CDS Planning and Development Consultancy

Planning Application
44 Murray Road, Northwood, HA6 2YL
Planning Application 1787/APP/2025/1849

I have the pleasure of attaching a formal amendment package which responds comprehensively to the points raised during our discussions. This letter summarises the key amendments and provides additional clarification where further information was requested.

Drawing Number	24 / 3555 / 11	Revision	A
Date	12 / 12 / 25		
Scale	1:200 @ A1

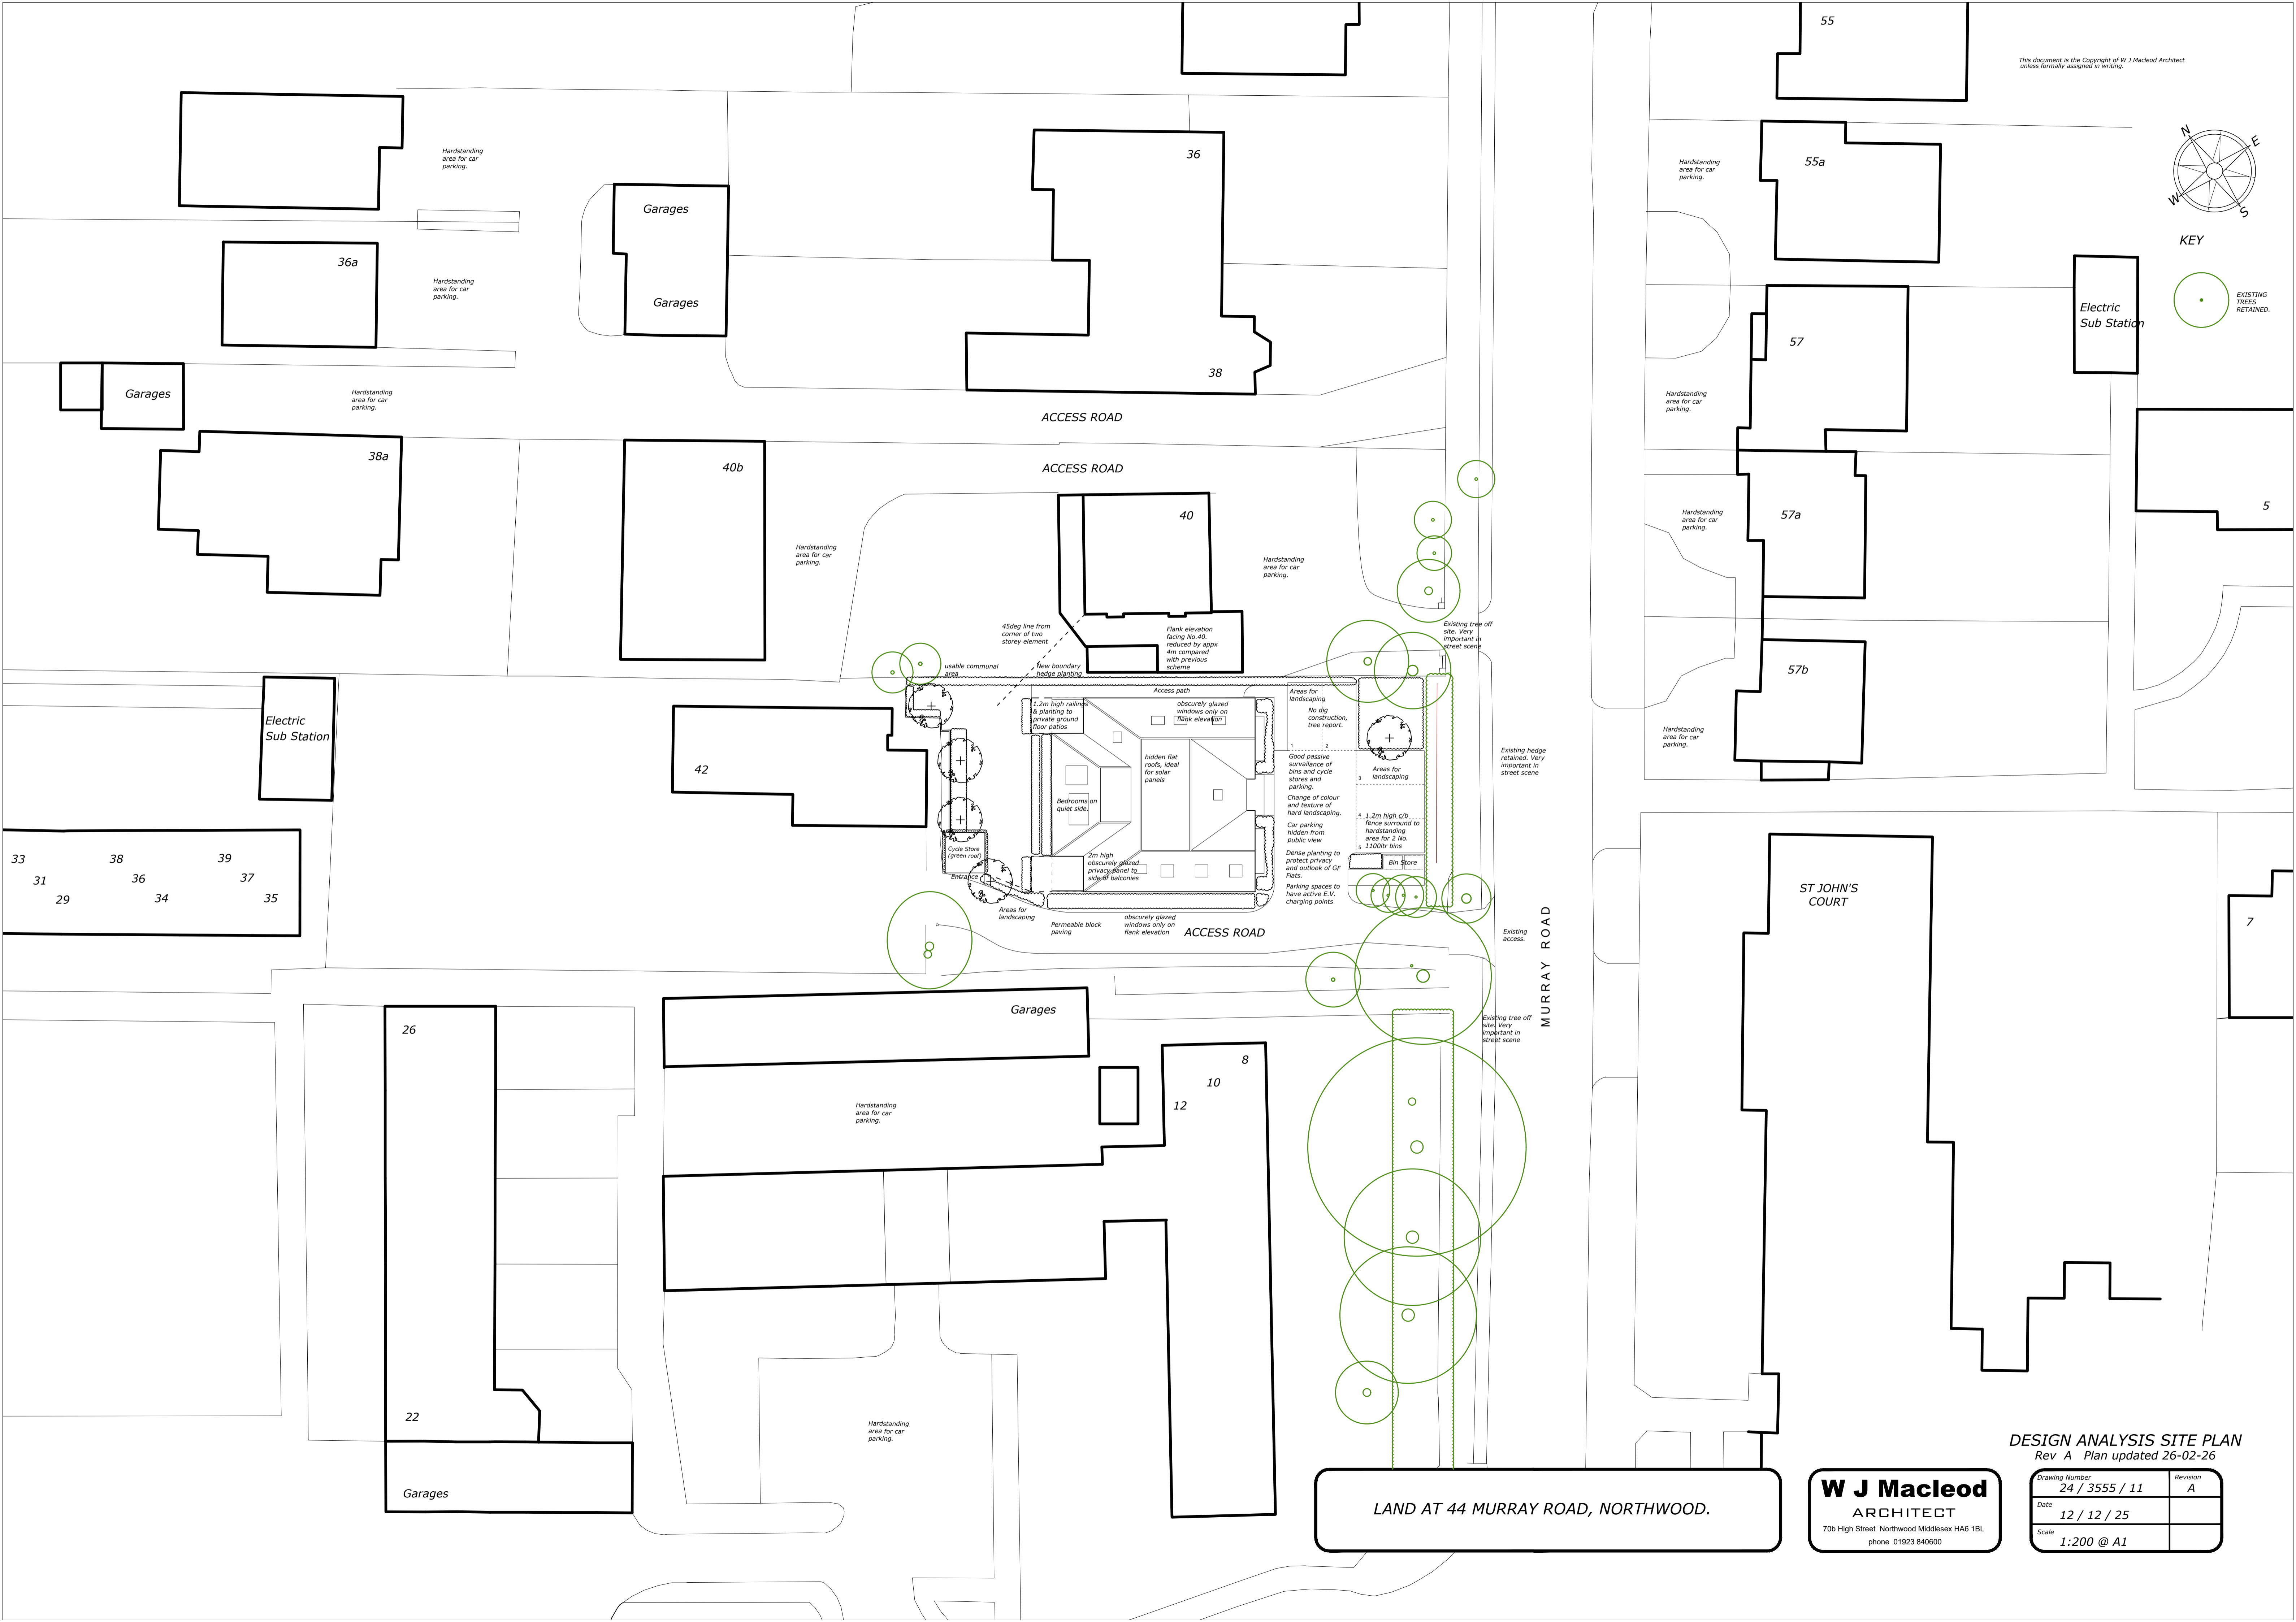
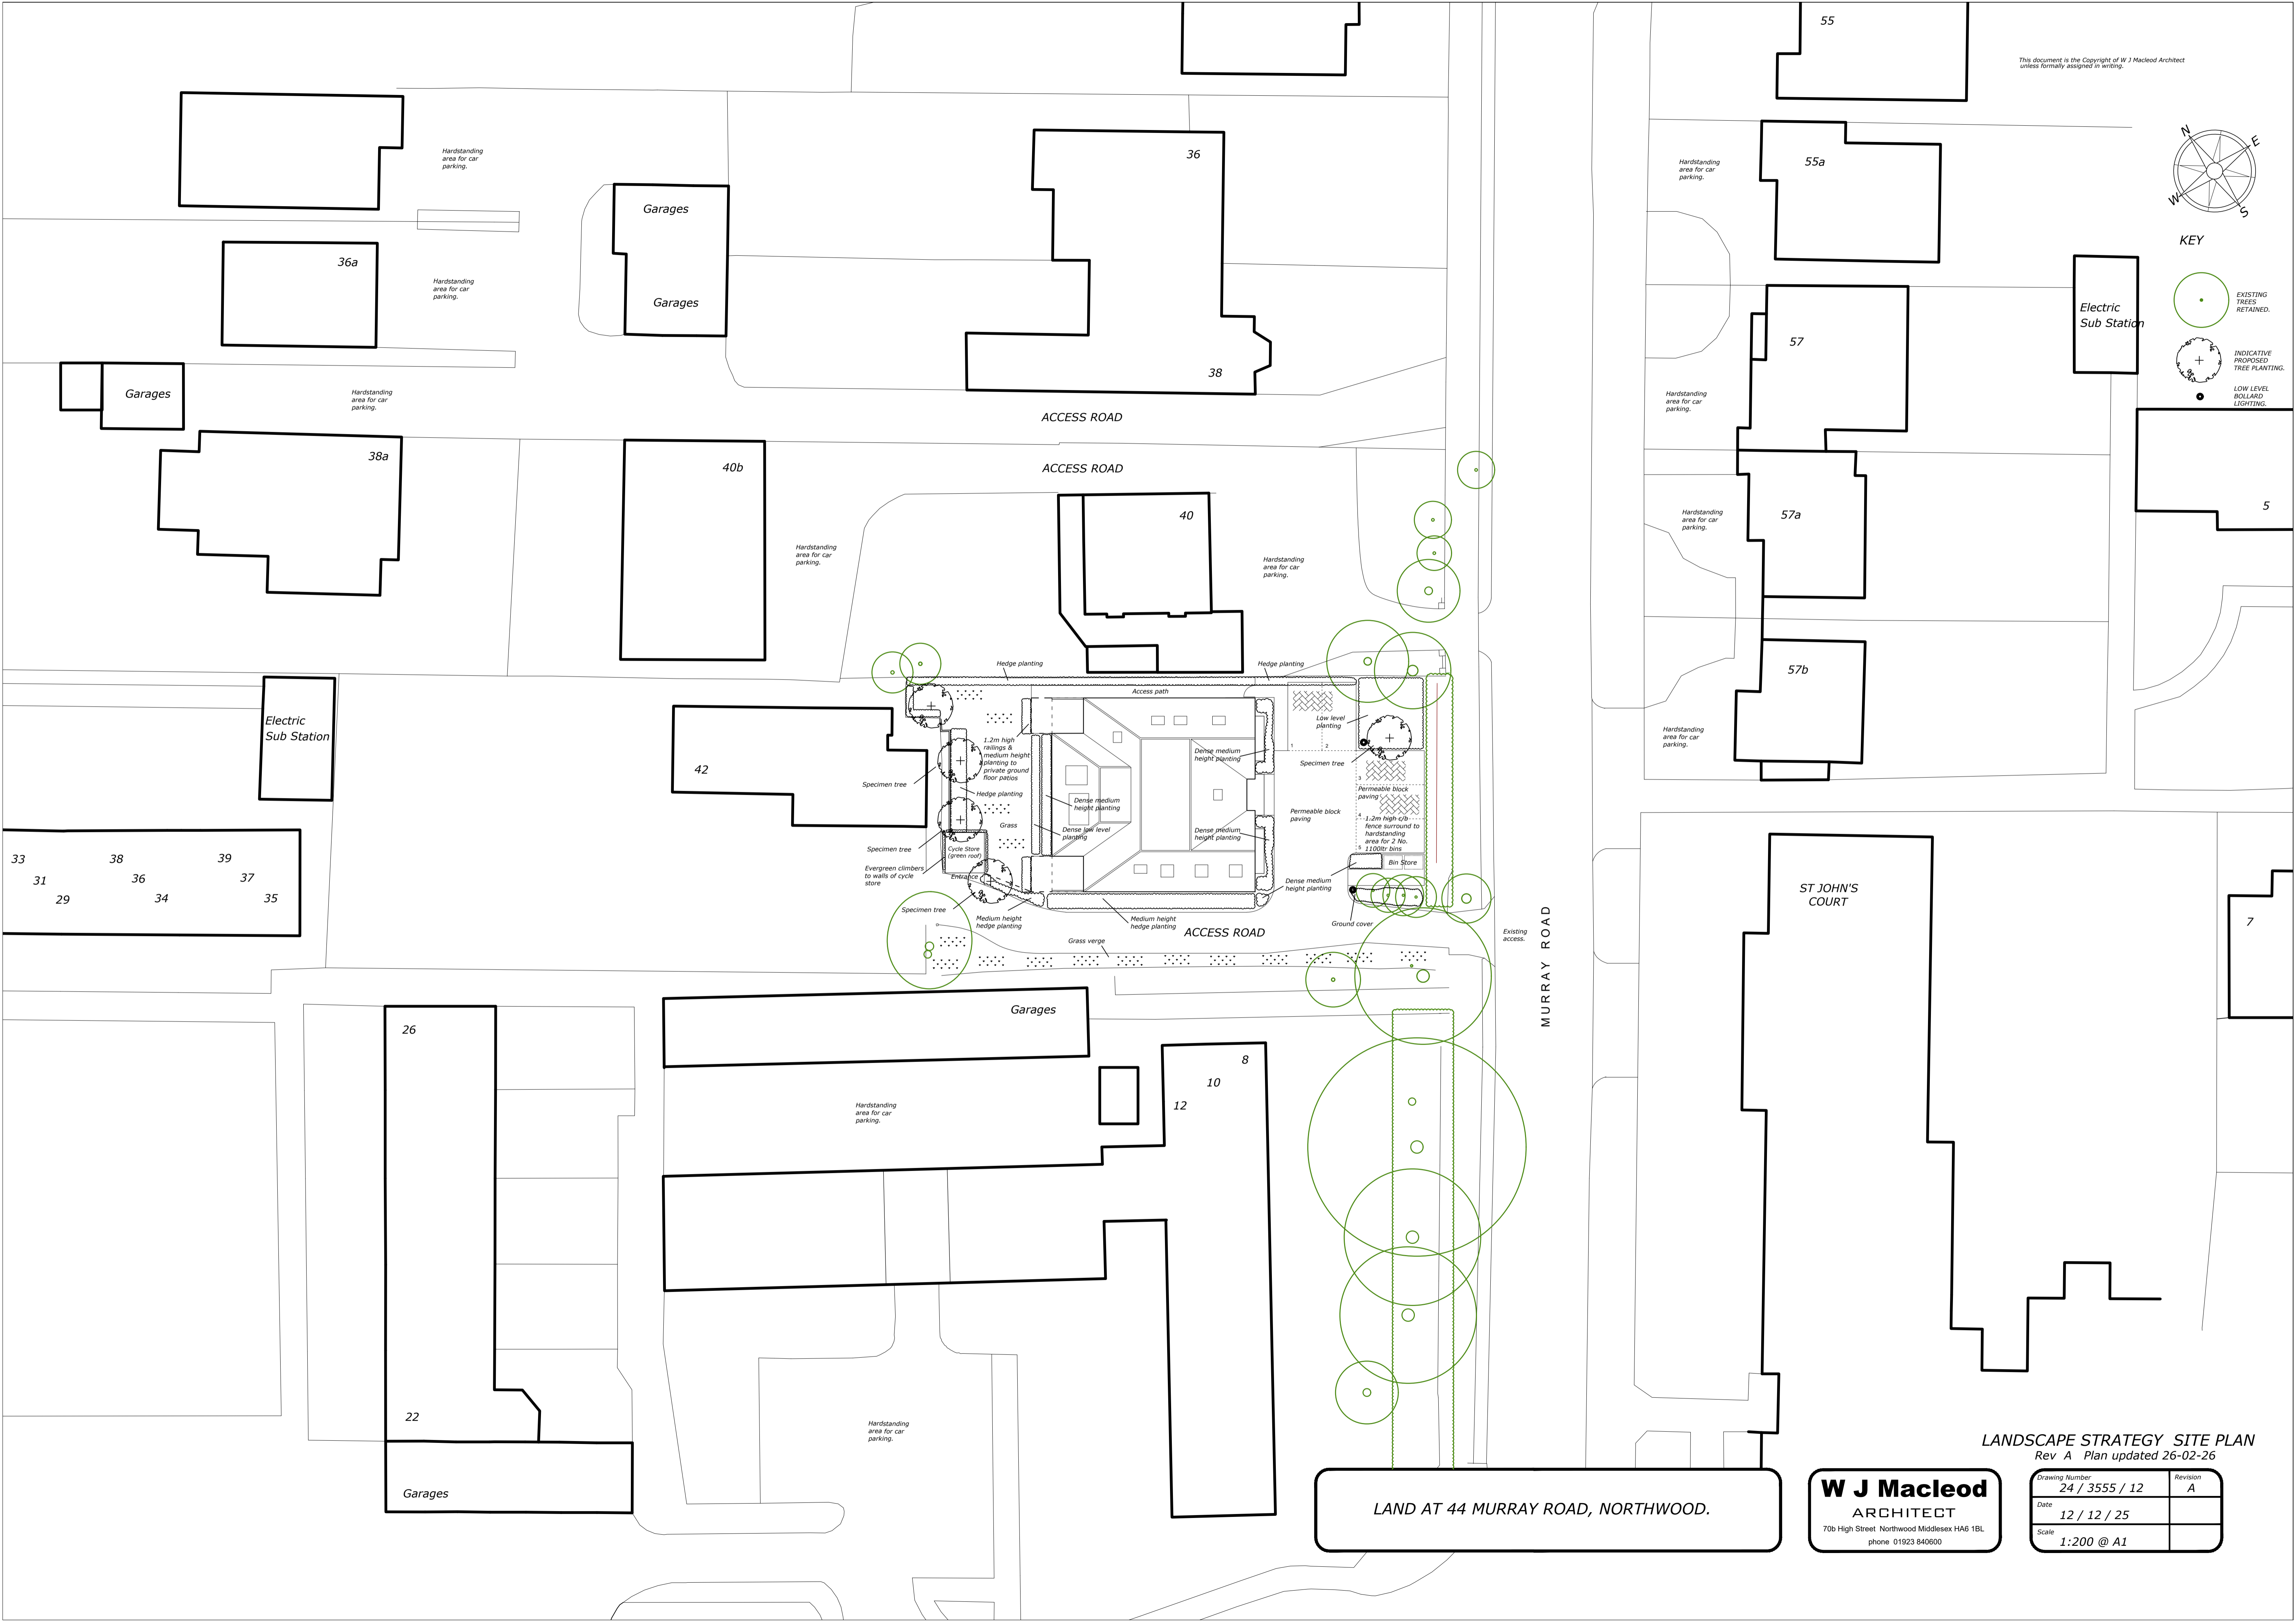
Concerns were raised regarding the reduction in soft landscaping to the site frontage.

Clarification was also sought regarding the positioning of the cycle store and refuse areas adjacent to the amenity space.

The revised retains the existing hedge, and the parking arrangement has been rationalised to allow for increased soft landscaping. Ancillary structures have been relocated away from the primary landscaping areas, enabling the introduction of more substantial and visible planting that will enhance the site when viewed both from Rickmansworth Road and on approach to the site.

In response, low-level fencing is now proposed, as shown on the site plan, to define and secure private amenity areas to the rear of Bedrooms 1 and 3 of the ground floor units. In addition, defensible planting and hedging can be introduced to the rear of the bedroom windows to further safeguard privacy. These measures will ensure a high-quality and policy-compliant level of residential amenity for future occupiers and could be secured via planning condition if considered necessary.

Further details are now shown on the revised site plan illustrating how residents would access these facilities, together with details of the cycle store itself. Access routes would be hard landscaped to ensure usability in all weather conditions.

We have also reviewed the rear amenity space and removed the washing dryer and some of the paving as to increase the level of soft landscape.

Floor Plans and Elevations

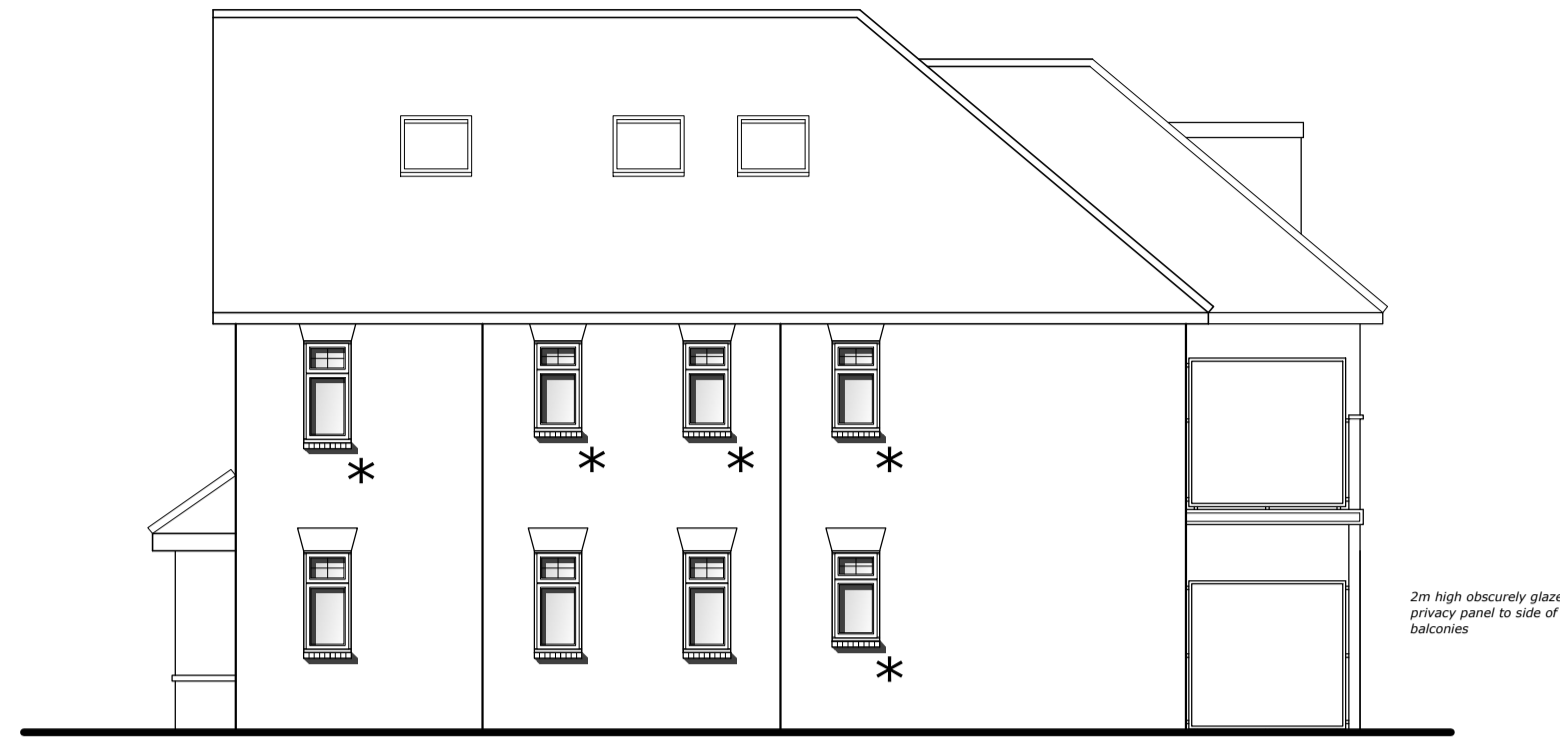
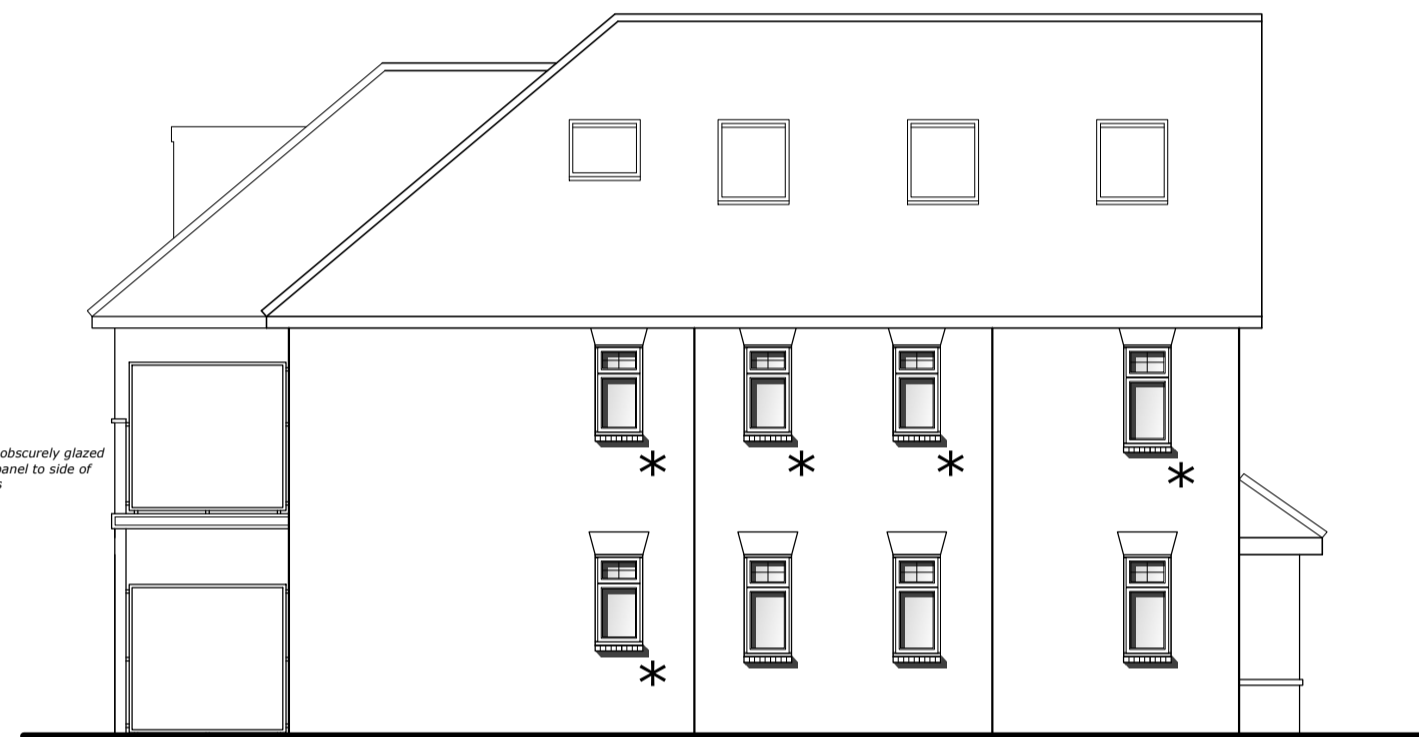
Concerns were raised that the architecture appeared overly complex within the context of the street.

Officers also raised concerns regarding the projecting bay features. These have now been omitted entirely. The revised design adopts more traditional window and door arrangements, with improved vertical alignment across floors and a clear and respectful window hierarchy.

In response, the design has been simplified while retaining an appropriate level of architectural interest, ensuring that the building does not appear overly plain within the streetscape. Amendments include a simplified front porch and the removal of front balconies, which the Council considered lead to a somewhat cluttered appearance. The arrangement of windows at ground and first floor level has also been refined so that the building reads more clearly as a single dwelling, helping it sit comfortably within the established character of the area. The overall design now presents a more restrained and classic façade, with fewer projections and recesses.
